from
**Southern
Water**

Your ref
BN/57/19/RES

Proposal: Approval of reserved matters for 2274sqm of light industrial floorspace (Class B1 (b)/(c)) following the grant of WA/22/15/OUT.

Site: BN/57/19/RES: - Land East of Fontwell Avenue, Fontwell Avenue, Fontwell BN18 0SB.

Draw No RA/032/50 SITE PLAN A

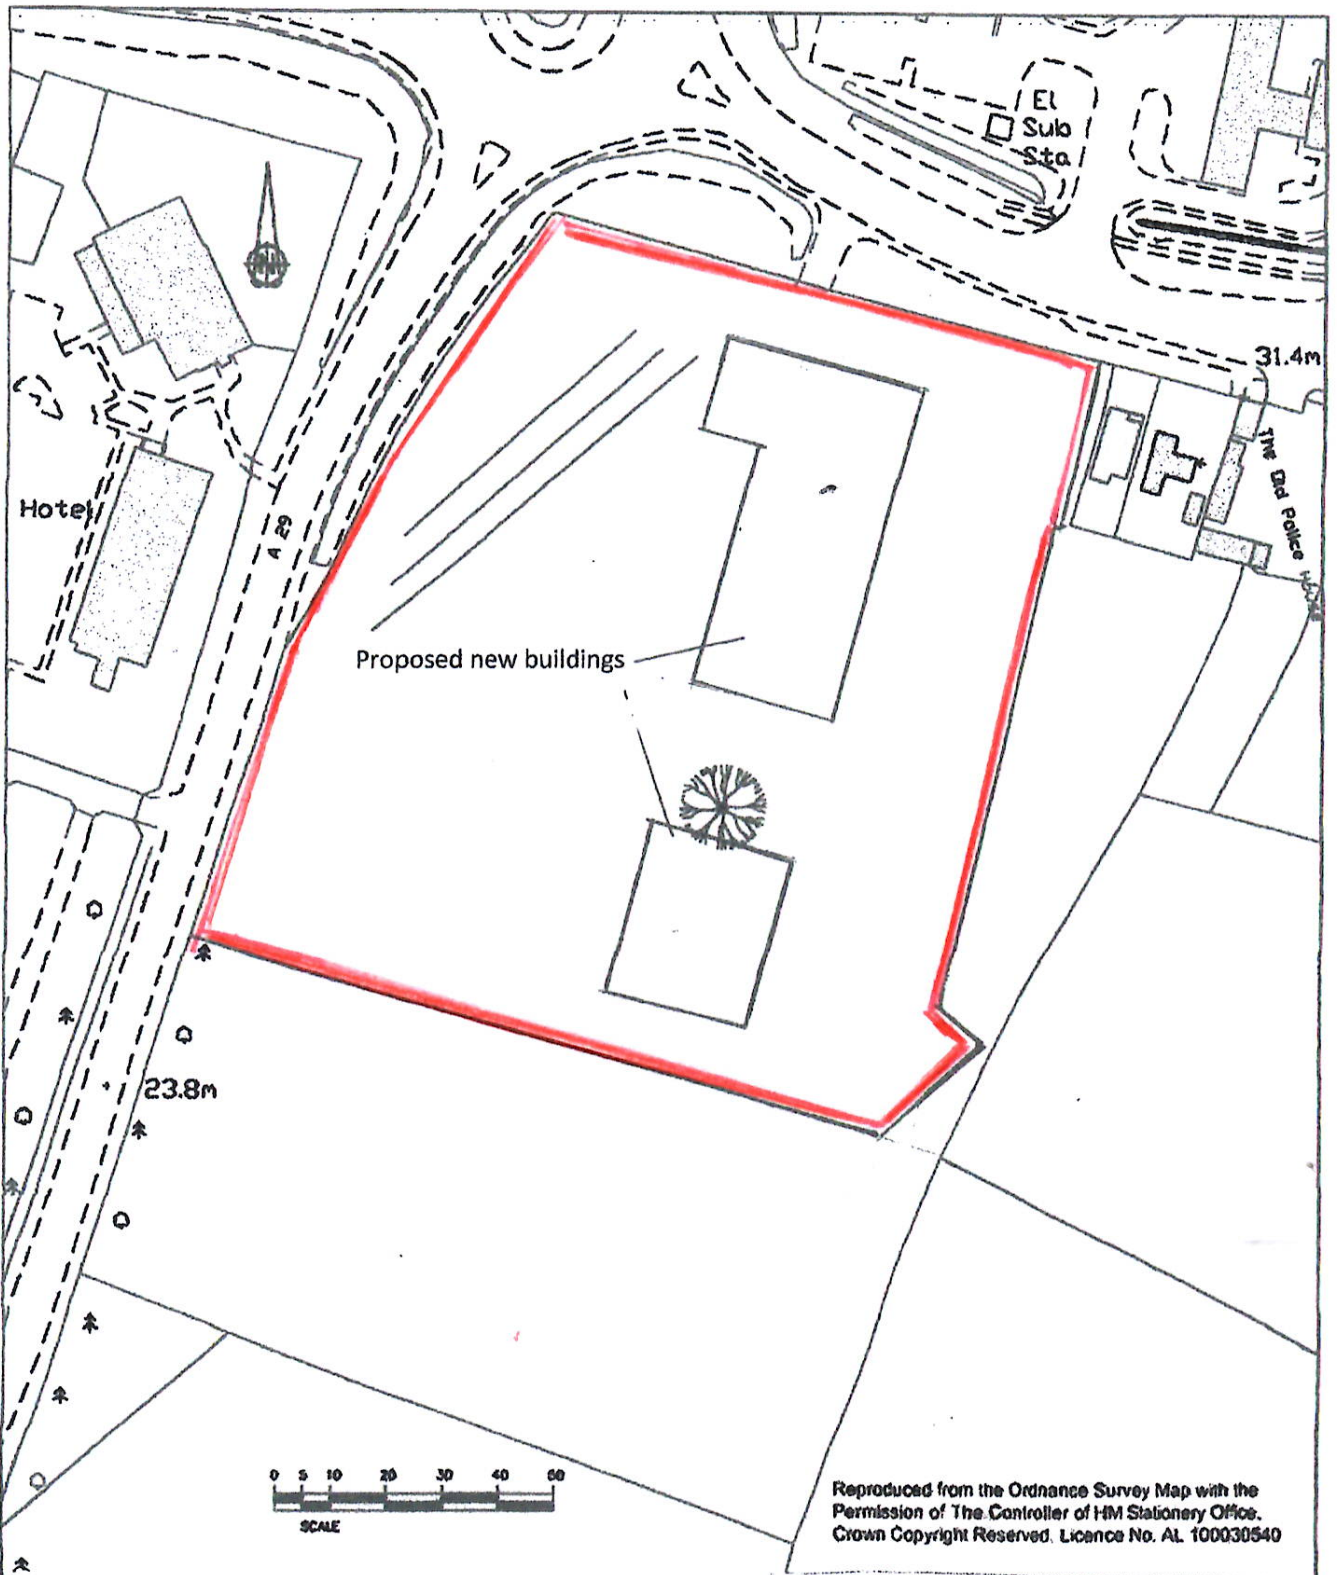
The submitted site plan indicates tree planting close to public sewer. We have restrictions on the proposed tree planting adjacent to Southern Water sewers, rising mains or water mains and any such proposed assets in the vicinity of existing planting. Reference should be made to Southern Water's publication "A Guide to Tree Planting near water Mains and Sewers" and Sewers for Adoption with regards to any landscaping proposals and our restrictions and maintenance of tree planting adjacent to sewers and rising mains and water mains.
